Application no: **3/2024/0278**

Address: **New Barn Farm Alston Lane Longridge PR3 3BN**

Proposal: **Proposed demolition of existing mixed use building and garages and erection of one replacement mixed use building for domestic garaging, equine storage and agricultural machinery.**

AS EXISTING

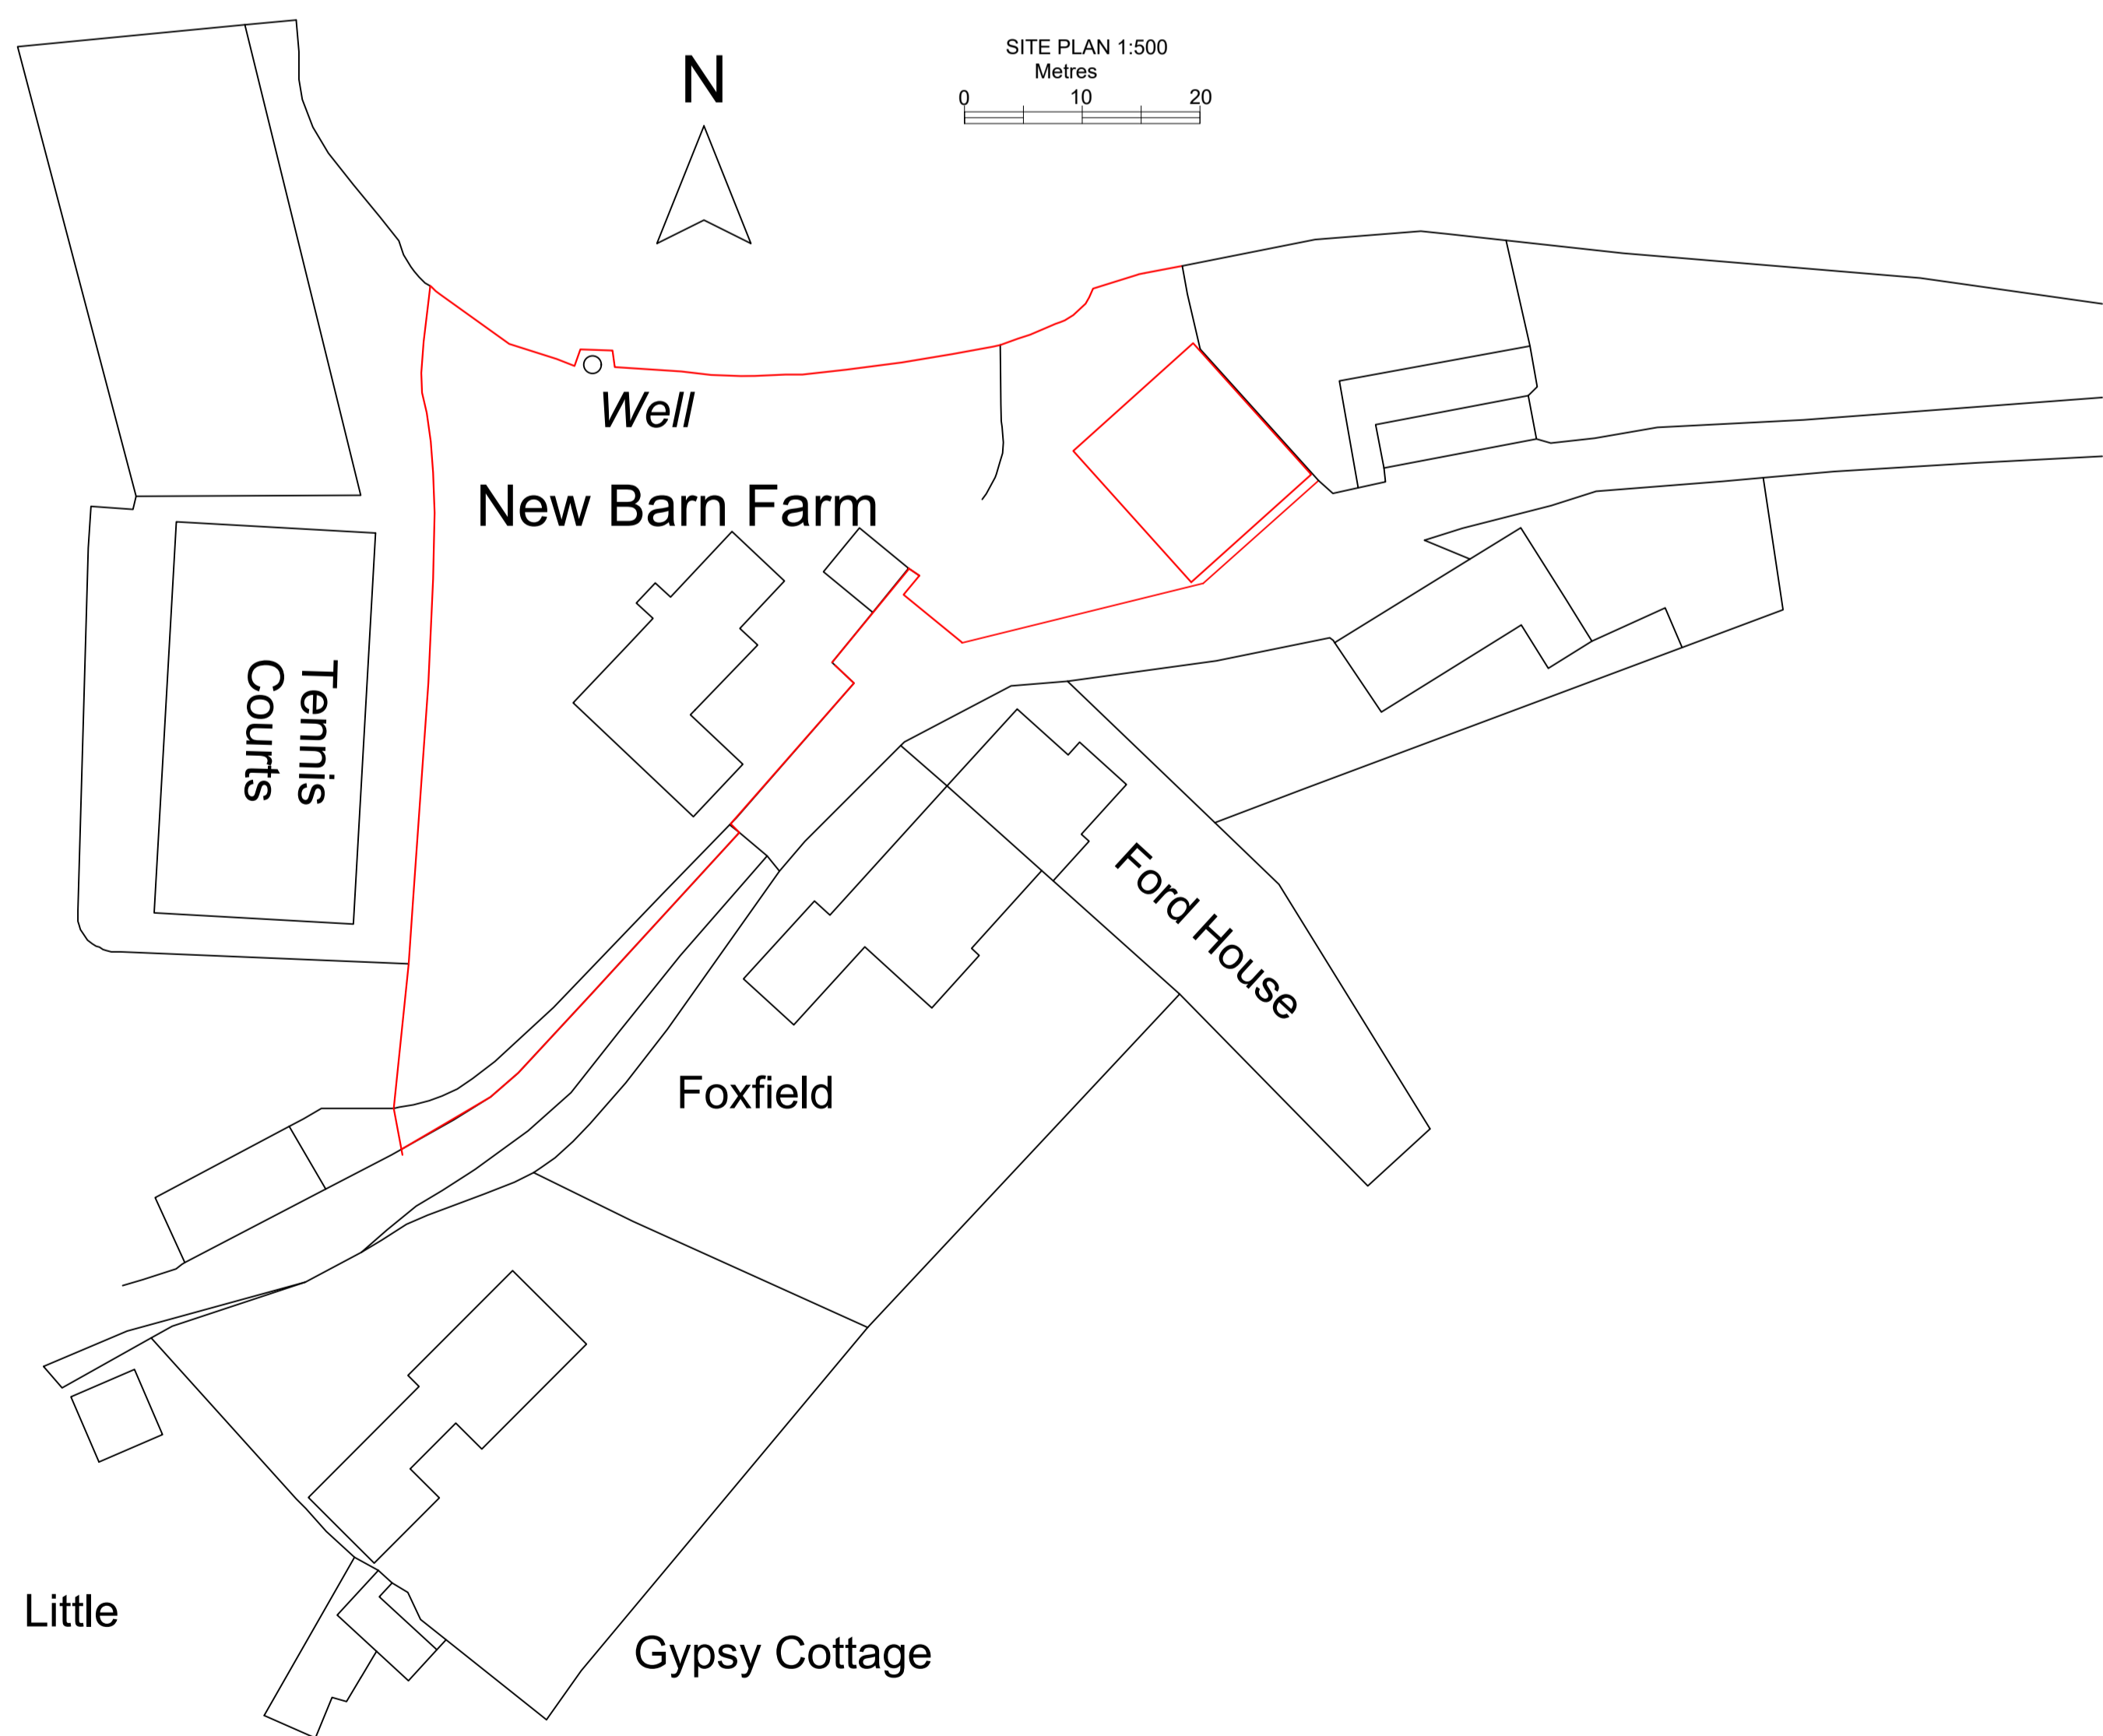
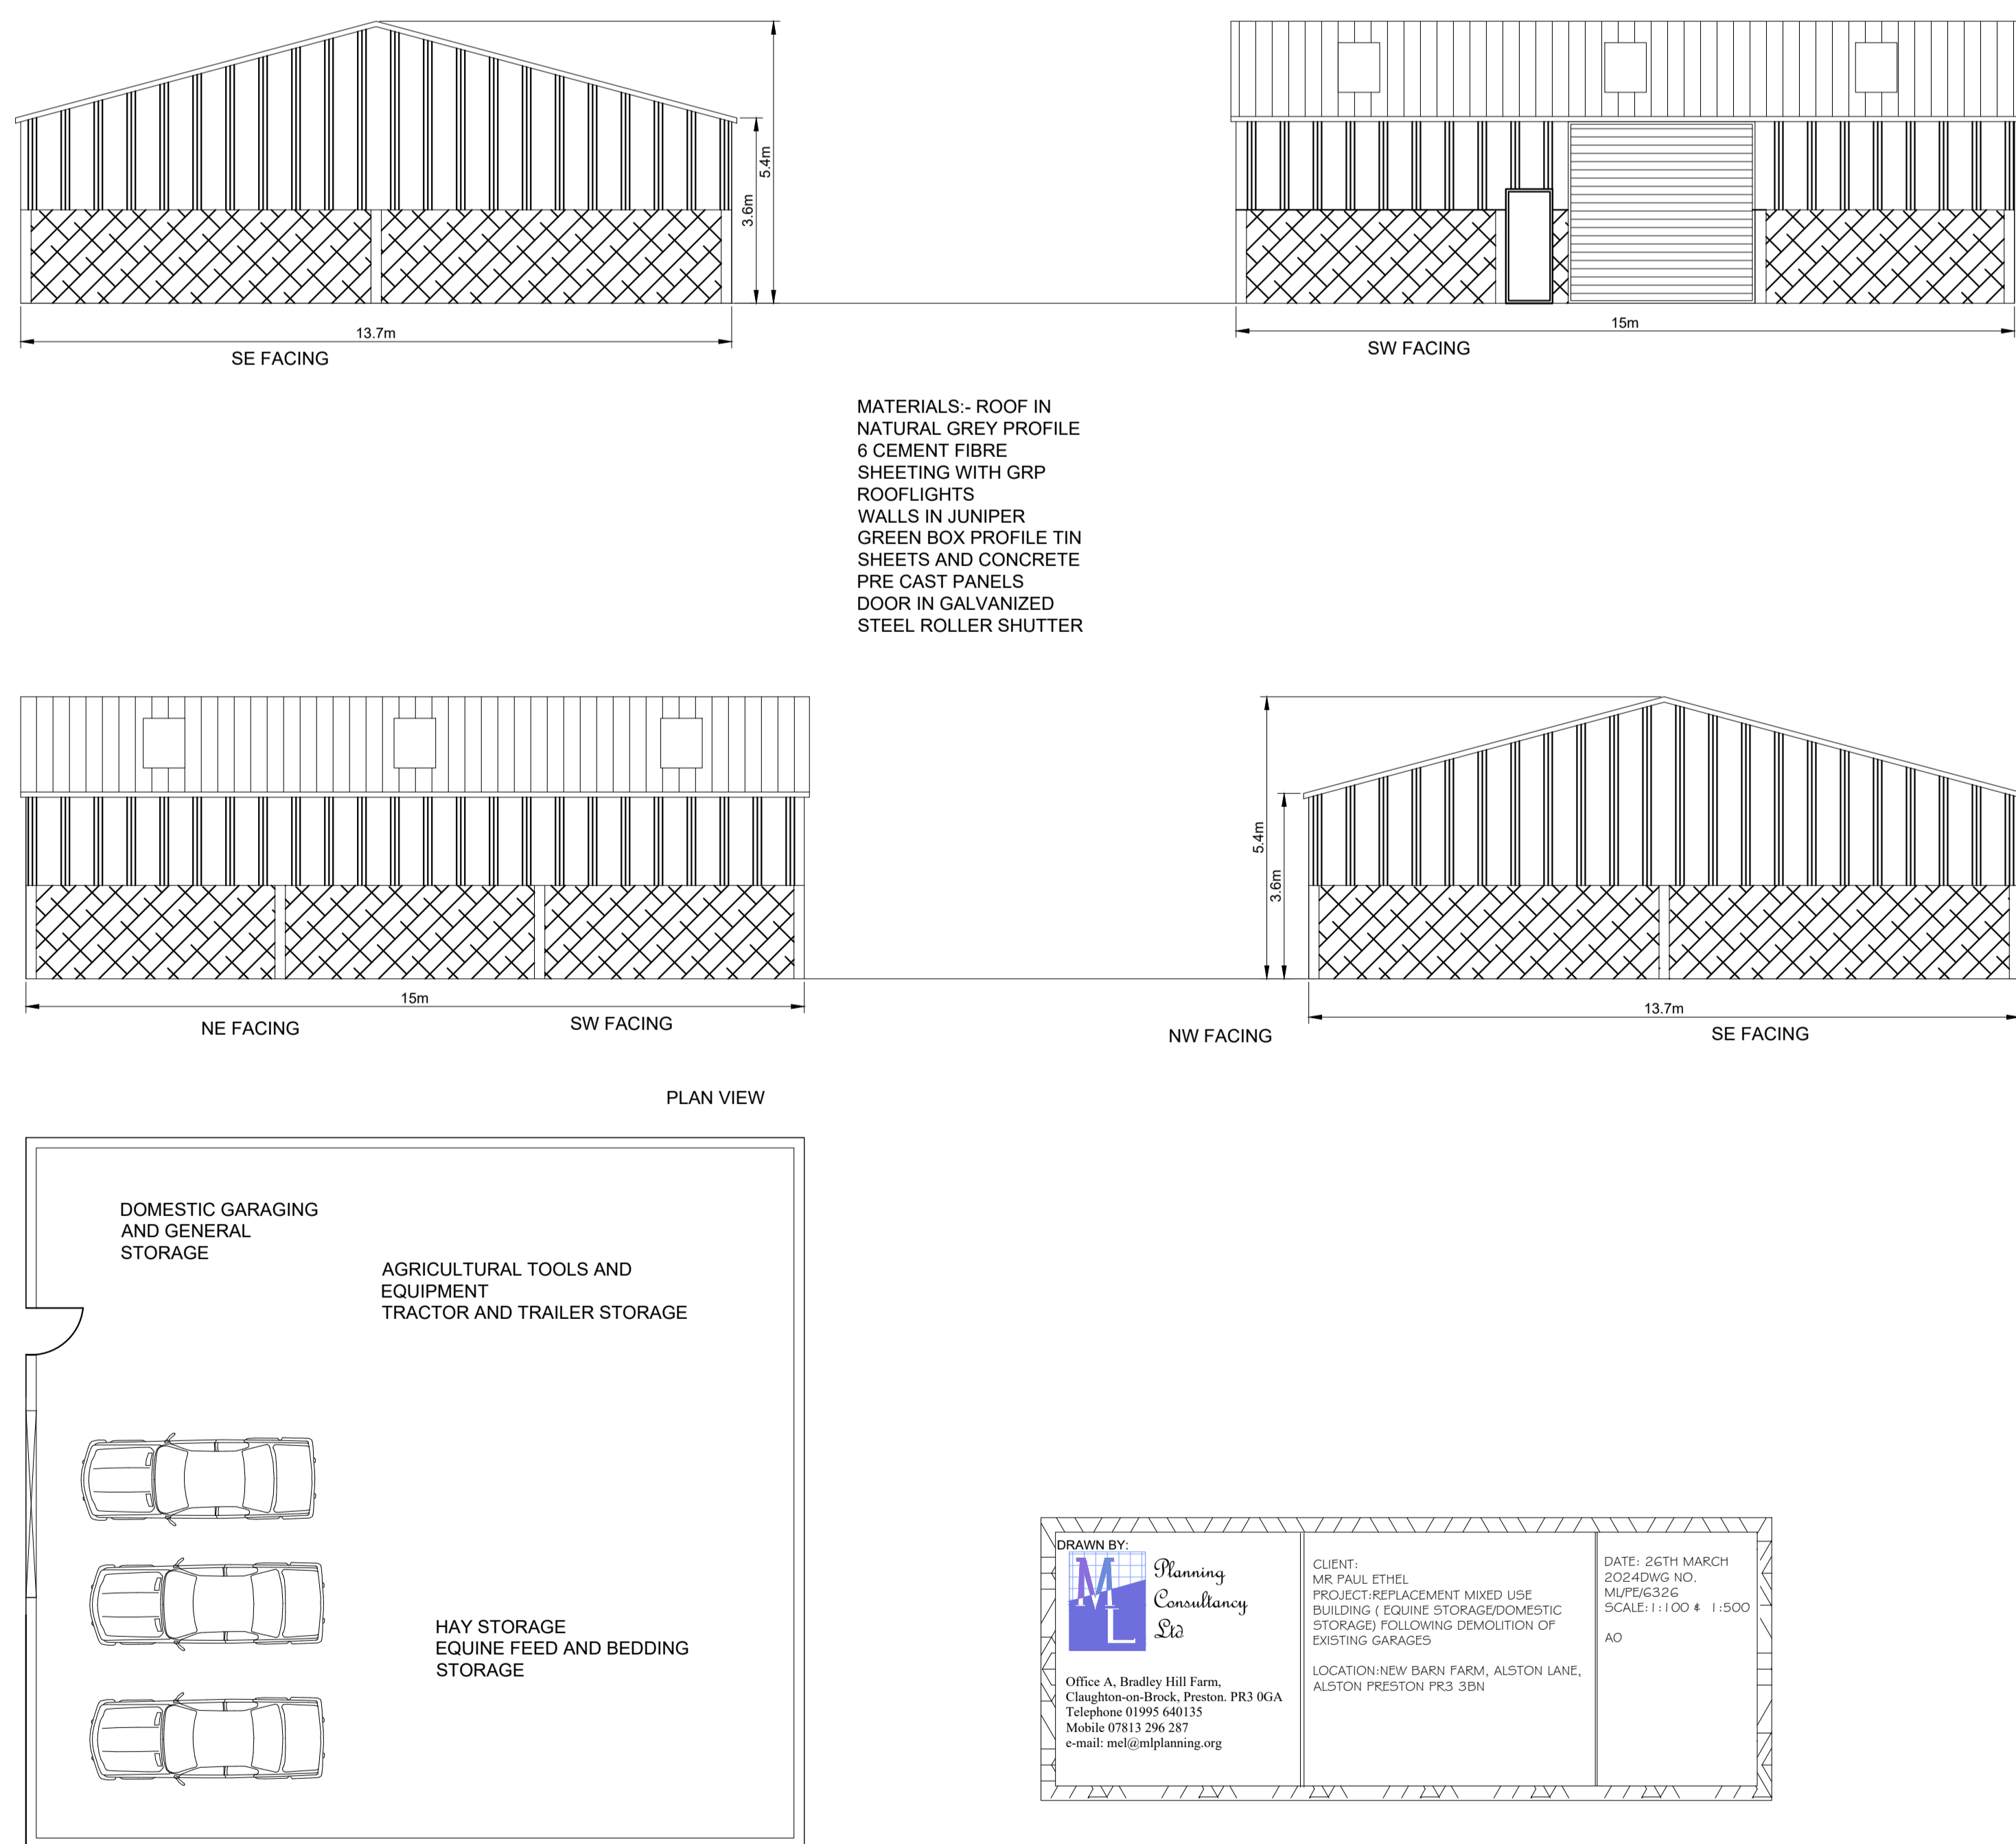
The LHA have reviewed ML drawing number ML/PE/6326 and require further information regarding the size of the existing and replacement building. This is because should the replacement building be bigger than the existing building, the proposal may conflict with the definitive line of the Public Right of Way, FP0302073 which runs past the existing building into the adjacent field to the north. As a result of this, to ensure that there is no conflict with the Public Footpath following the proposal, the LHA require an amended plan showing the proposed building in relation to the Public Footpath.

The LHA require an amended plan to be submitted showing the location of the proposed building in relation to Public Footpath FP0302073, which runs past the existing building into the adjacent field to the north. This is to ensure that the footprint of the proposed building does not conflict with the Public Right of Way.
